An  
Bord  
Pleanála

## Inspector's Report

### ABP-317874-23

Extraction of sand and gravel from quarry. An Environmental Impact Assessment Report (EIAR) and a Natura Impact Statement (NIS) have been submitted.

**Haul Road Layout Plan
Scale - 1:600**

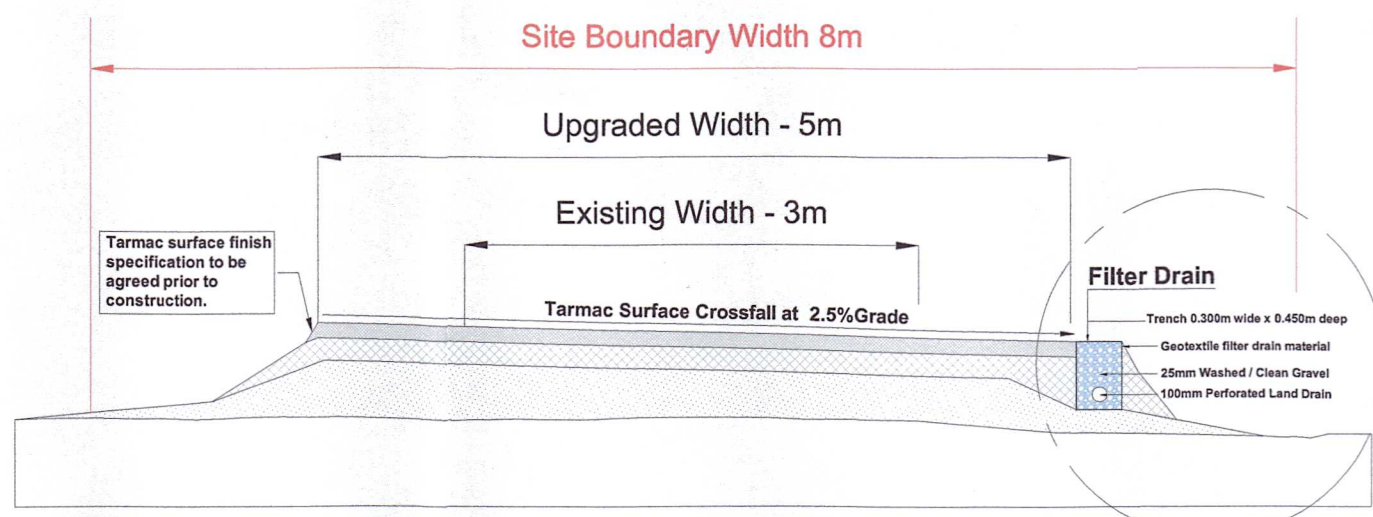
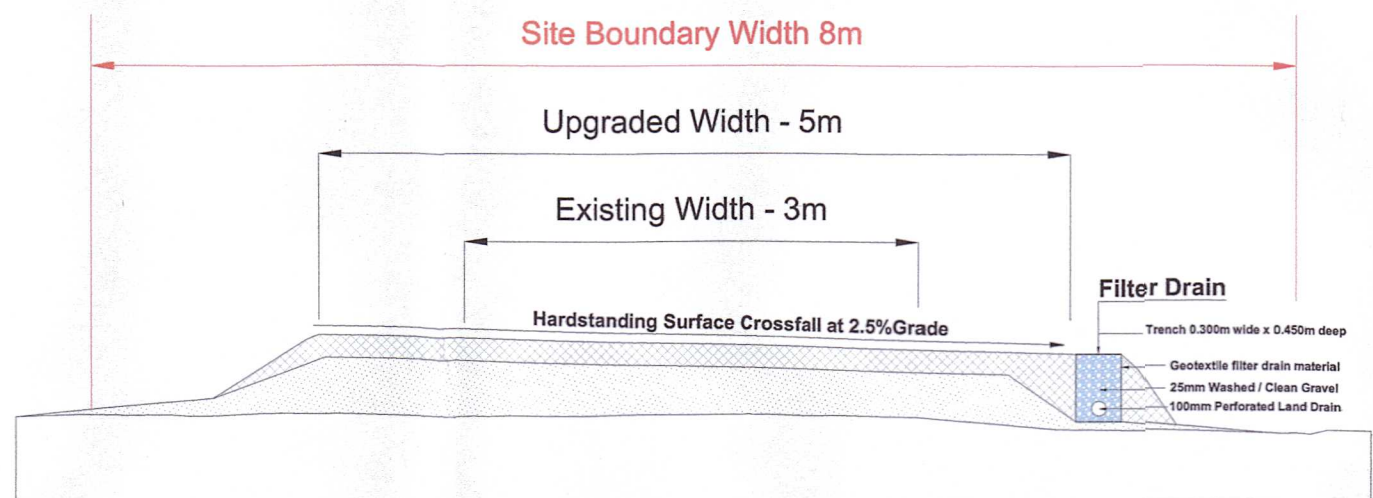
- The haul road as it approaches the new bridge structure is to be cambered to allow any surface water to drain to each side, hence mitigating any potential run off of silt into the stream. This is in addition to the proposed silt fencing that has been specified.

Second report on file which again recommended FI with respect to the requirement to submit a construction management plan (CMP) and update drainage drawings.

Longitudinal Section of Haul Road
Scale: NTS

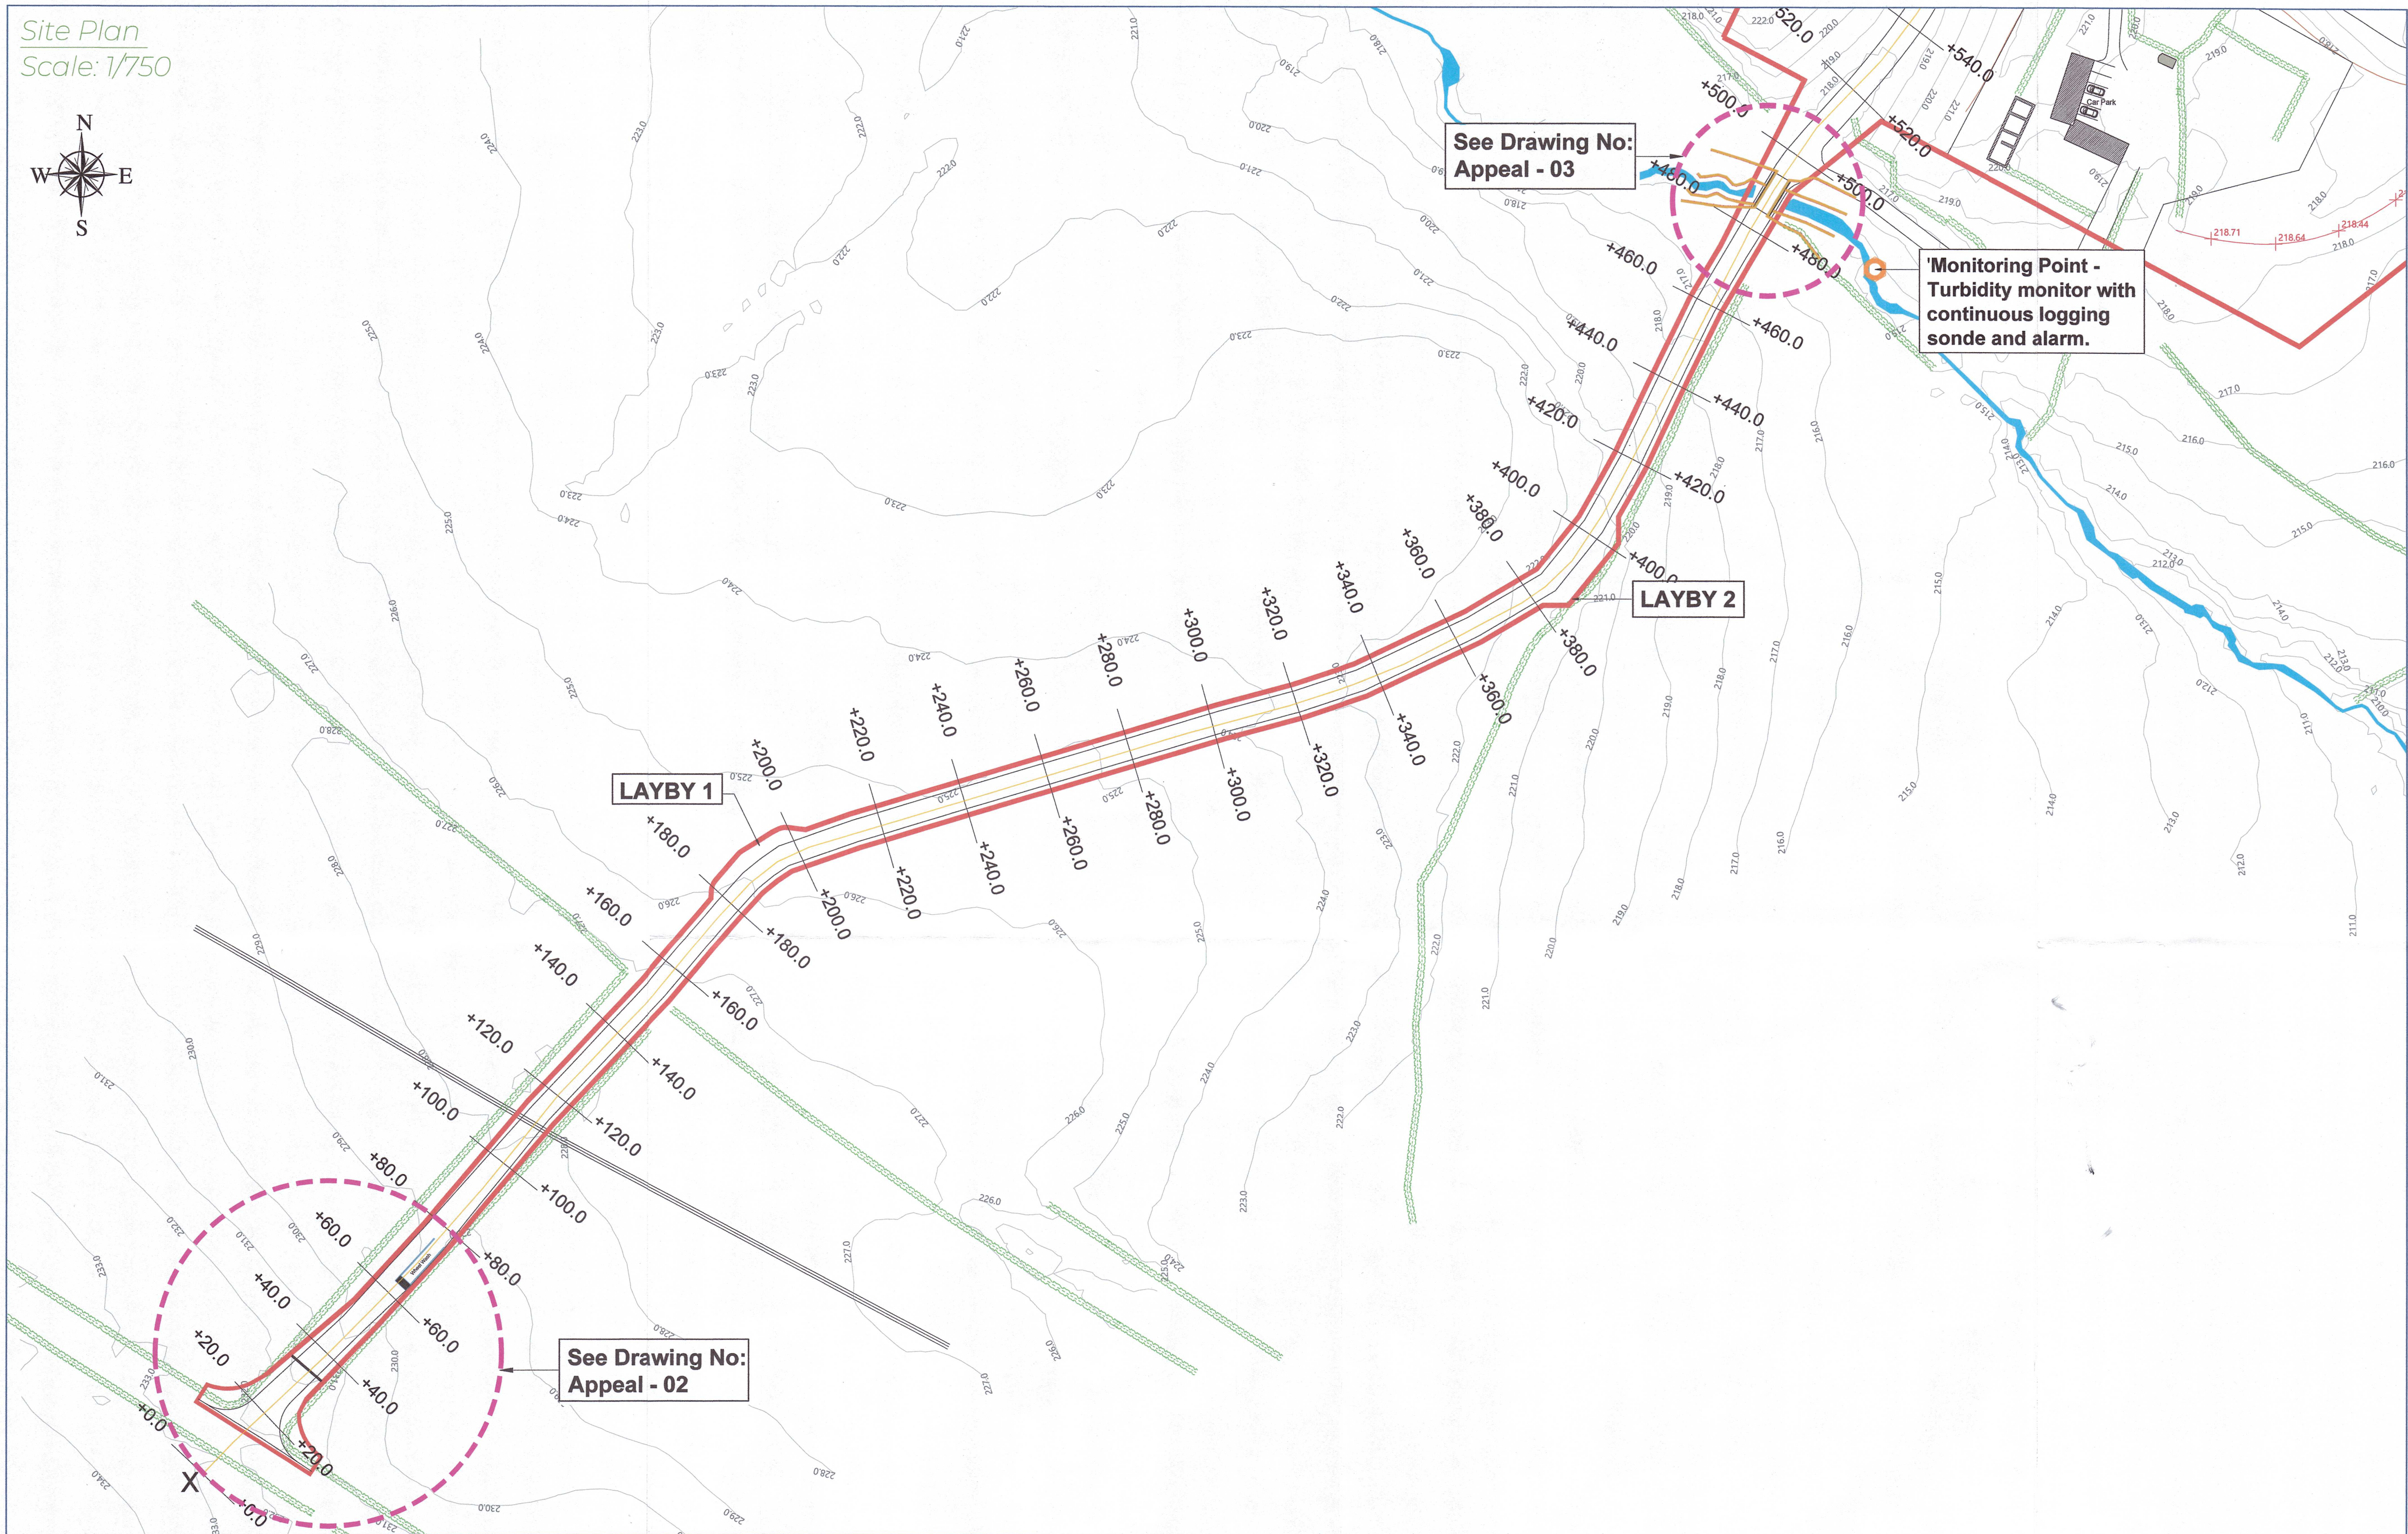
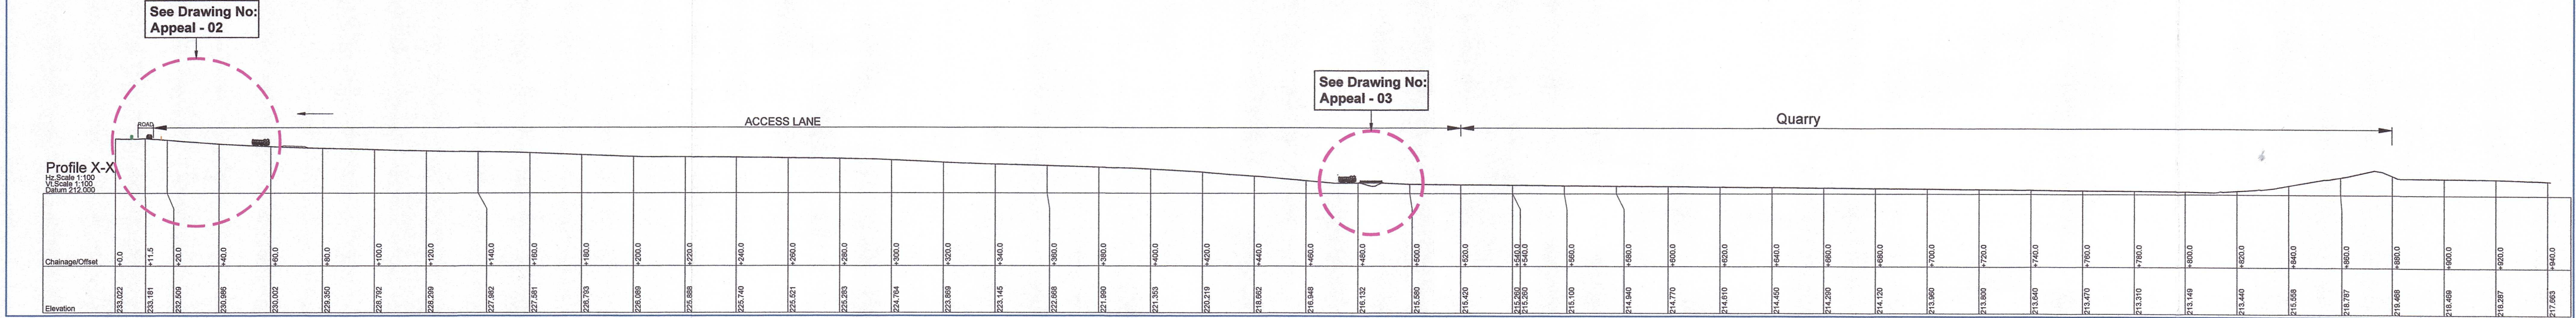
- The Haul Road Section Drawing No. AI-04 proposes a tarmacked surface from the edge of the R756 to the relocated wheel wash. A new gate is set back 17m from the edge of the R756 with an Aco drain set back 20m.

SILT FENCE SECTION AT BRIDGE

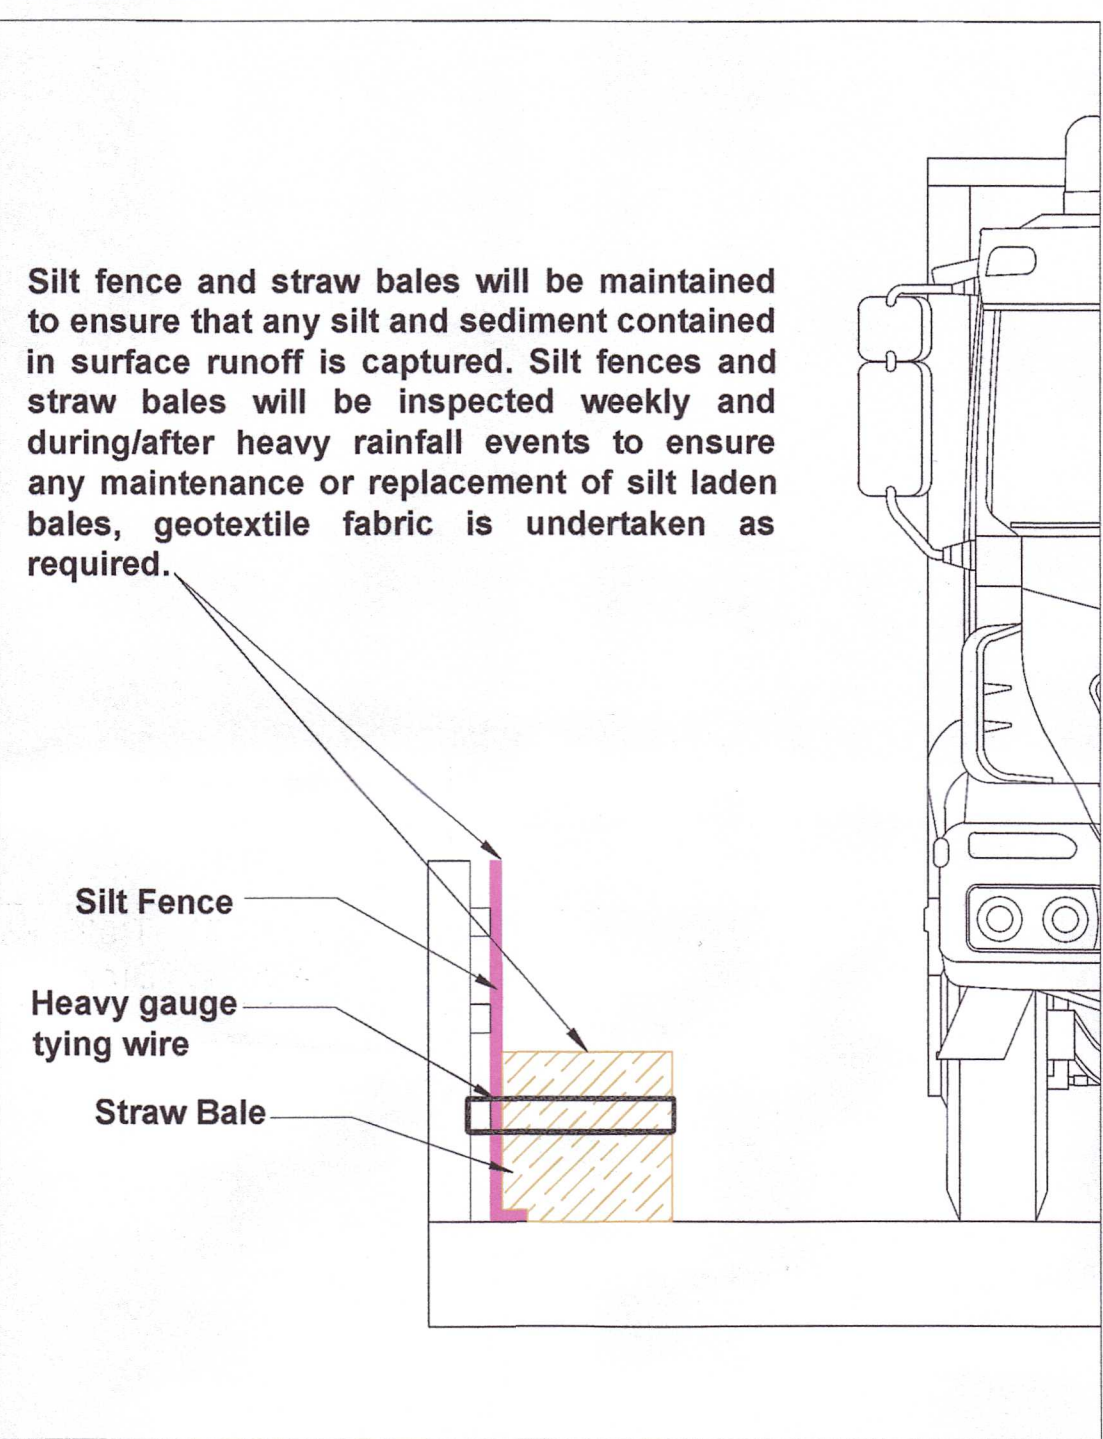
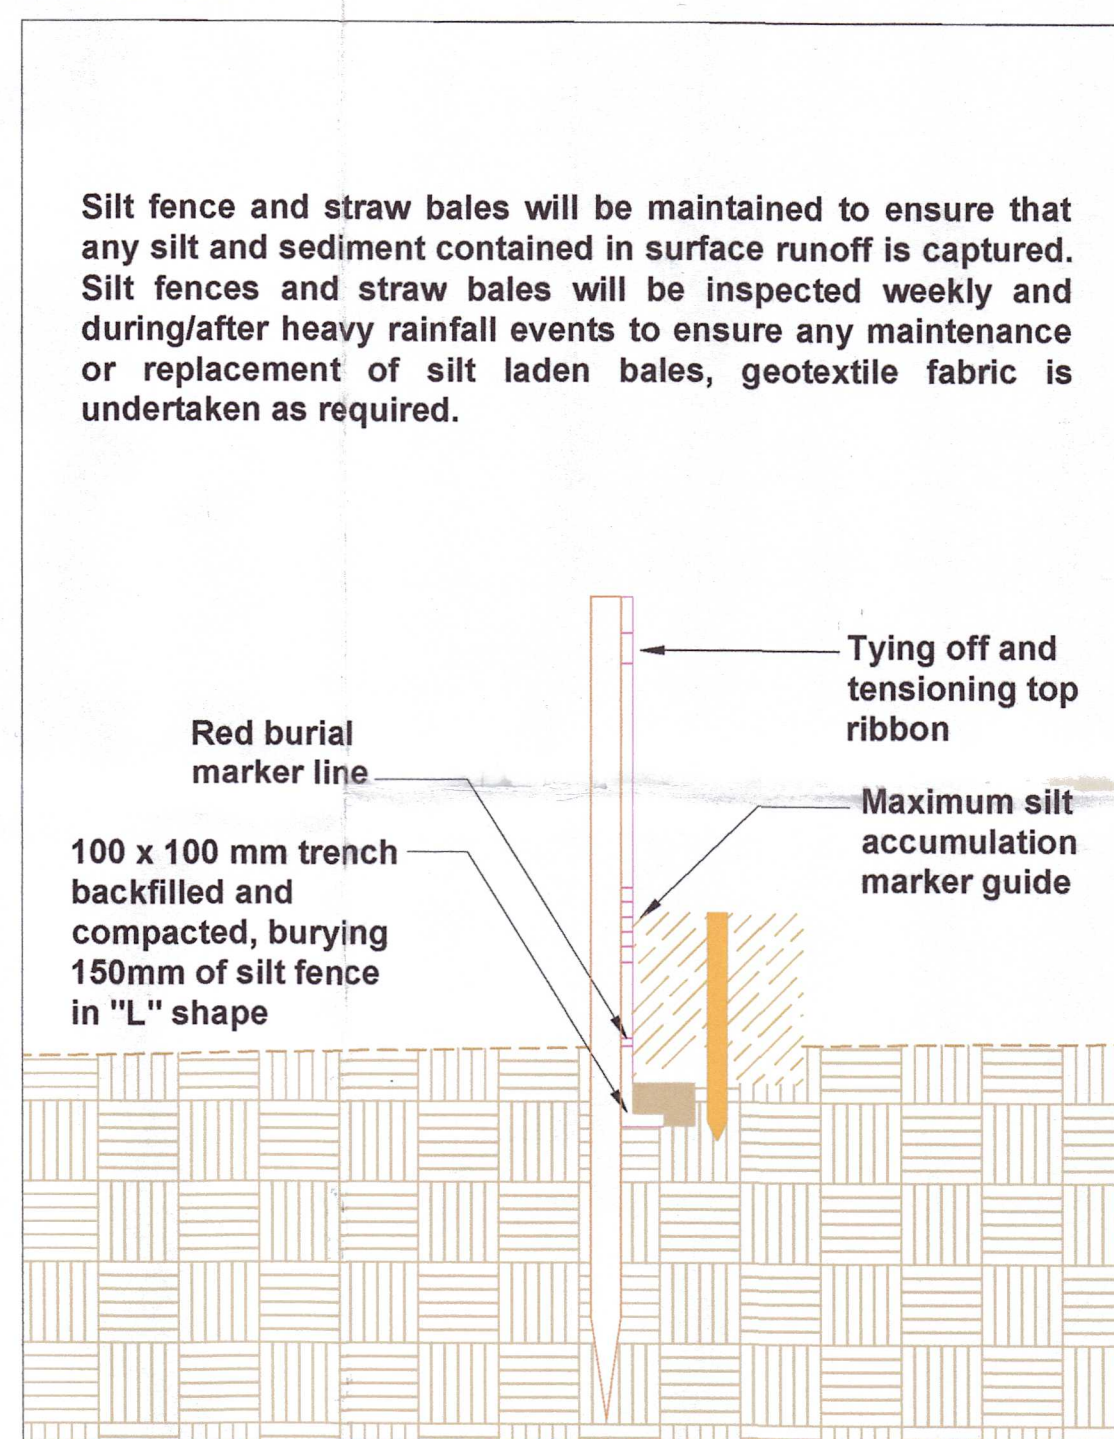
- Having regard to the location of the proposed quarry, and the lack of sufficient detailed information in respect to the archaeology, baseline noise, road network, dust plumes, site specific bridge installation and silt fences, it is considered that the proposed development, notwithstanding the mitigation measures proposed in the Environmental Impact Assessment Report submitted would seriously injure the amenities of properties in the vicinity by reason of dust, noise, would have an adverse impact on the water environment and biodiversity of the area, would result in a traffic hazard. The proposed development would, therefore, be contrary to the proper planning and sustainable development of the area.

- In terms of the bridge details, it is proposed to install 4x10m lengths of silt fencing upstream and downstream running parallel to the riverbanks at the top and bottom of the bank, in addition to the already specified silt fencing attached to the bridge as originally proposed.
